KITTITAS COUNTY FIRE PROTECTION DISTRICT 7

Re: Mountain River Trails Application

Kittitas County Fire District #7 appreciates the opportunity to provide comment regarding the proposed campground within the F-R (Forest and Range) zone.

MOUNTAIN RIVER TRAILS

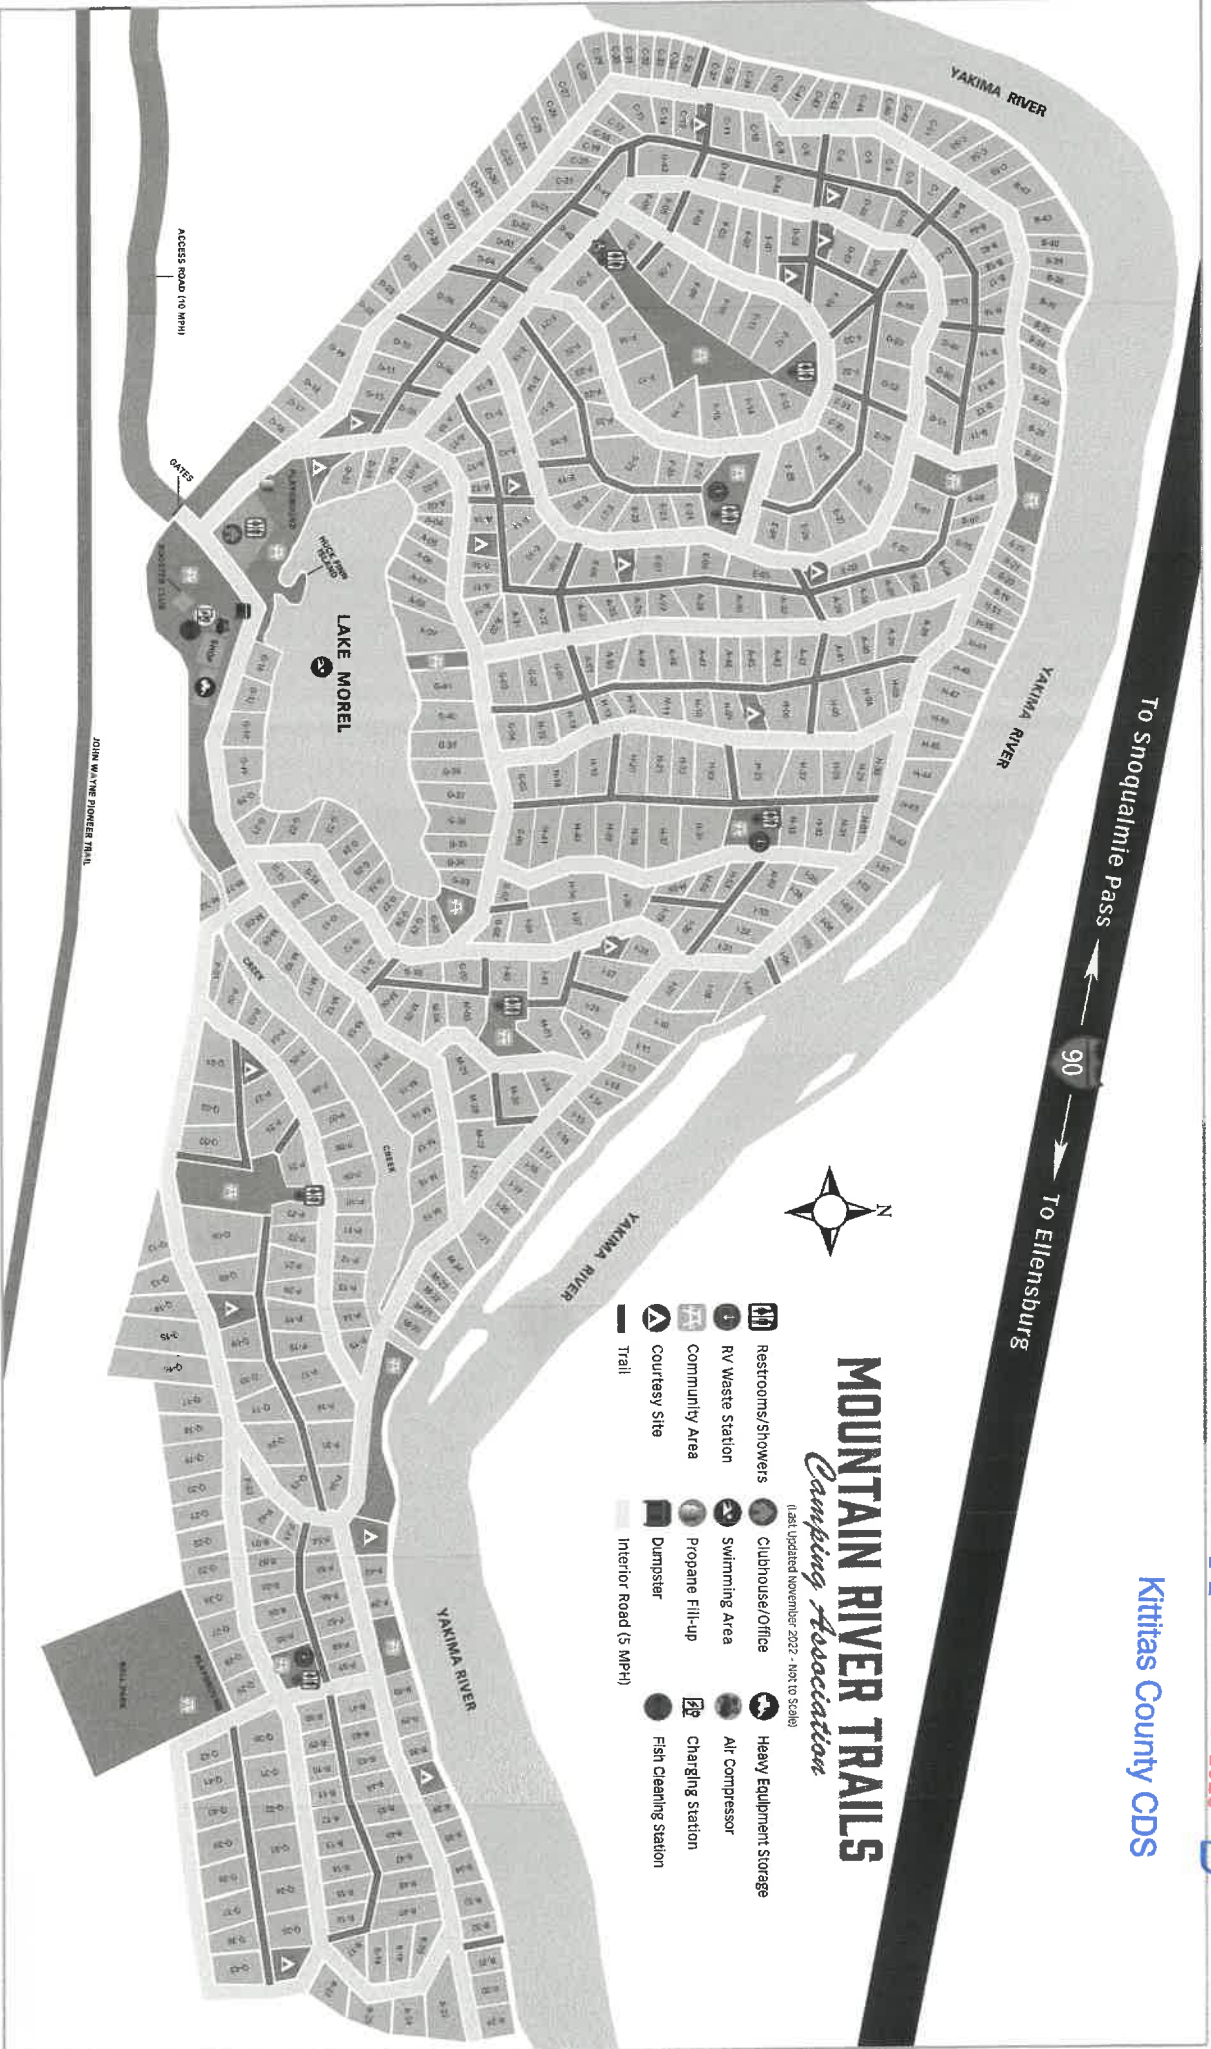
For effective emergency response, it is essential that every campsite, RV pad, rental unit, and occupied location within the development be assigned a **unique, clearly visible, and county-compliant address or site number**. There have been prior incidents at this campground where incomplete or unclear site addressing created challenges in locating the caller or incident scene. These experiences highlight the importance of establishing a fully compliant and clearly visible addressing system moving forward.

Inaccurate, missing, or non-visible addressing directly increases emergency response time by delaying dispatch mapping, complicating responder navigation, and impairing location verification—especially during low-visibility conditions such as smoke, darkness, or winter weather. The Fire District requests that the applicant provide a complete addressing plan that meets county standards and ensures rapid identification of all units during emergency operations.

Fire District #7 also emphasizes the need for all-weather, unobstructed emergency access that meets the required width, grade, and turning radius necessary for fire apparatus. Roads and drive aisles must be capable of supporting the weight and dimensions of emergency vehicles year-round. Clear access is critical for timely arrival, effective deployment of equipment, and the safety of both occupants and first responders.
